Section 96a Town and Country Planning Act 1990 25 Dulwich Village 20/AP/3206

Please find enclosed an application submitted under section 96a of the Town and Country Planning Act (1990) as amended, for non-material amendments to planning permission 20/AP/3206, granted in respect of 25 Dulwich Village, on the 15th January 2021.

A non-material amendment is sought to the approved refuse, recycling and bicycle stores and provision to the external yard.

CYCLE STORAGE PROVISION - CONSENTED SCHEME (20-AP-3206)

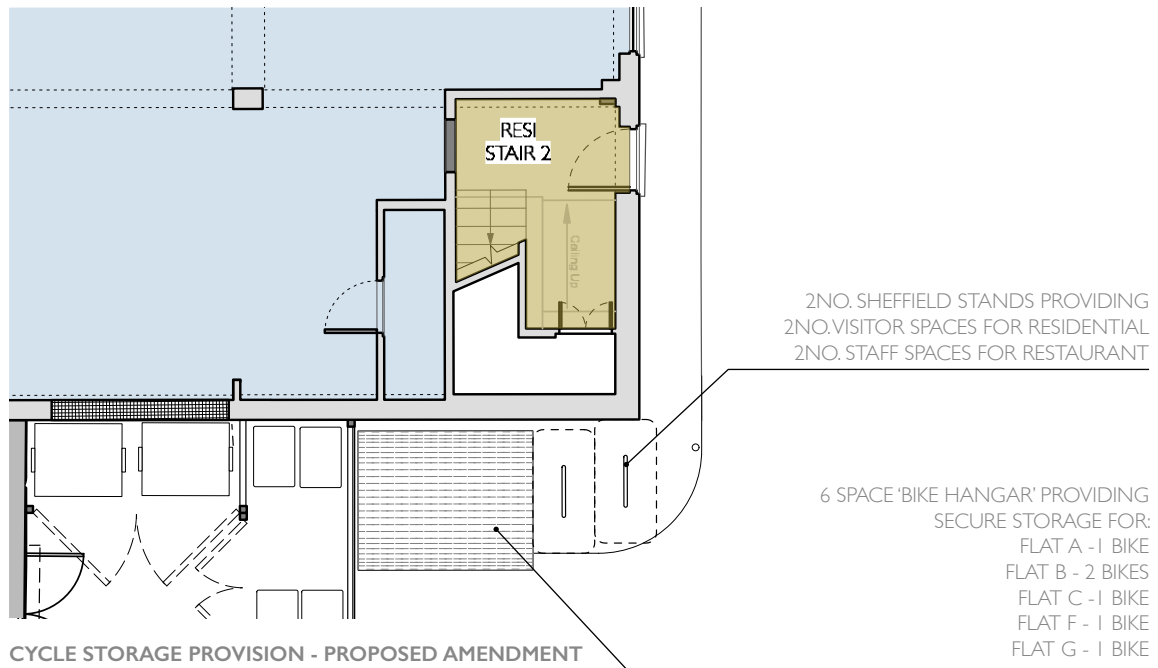
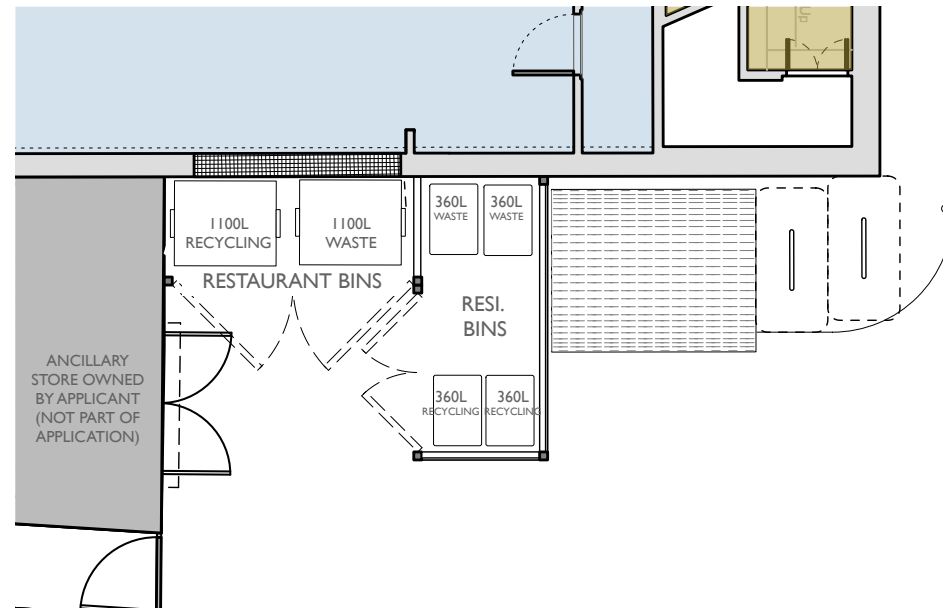
Following the grant of planning permission, detailed design work and liaison with the Building Control Approved Inspector has established that the one Sheffield stand approved within the residential core is not acceptable, in part due to the increasing use of electric bicycles and consequent fire risk.

A non-material amendment is therefore sought to reposition the approved bicycle parking provision, which necessitates a slight reconfiguration of the refuse stores. Two Sheffield stands (instead of the approved one) are now proposed adjacent to the hangar, with the refuse stores' size and orientation amended to accommodate the additional Sheffield stand.

There is no change to the quantum of bicycle parking, further the amendment is considered an enhancement as all of the permanent residential bicycle spaces will be within the secure hangar, with the Sheffield stands providing restaurant staff and residential visitor spaces.

SOUTH ELEVATION BIN AND SECURE CYCLE PROVISION

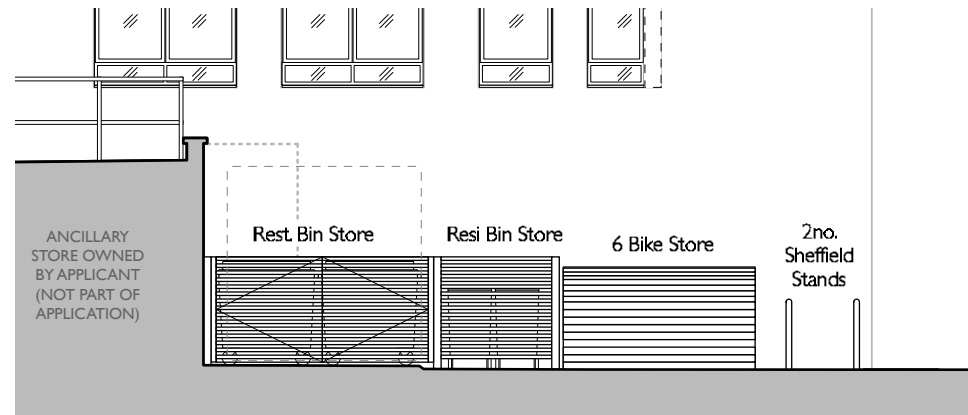
There is no change to the number of bins proposed, and they remain within separate, timber slatted stores. It is only their form and orientation which is slightly amended.
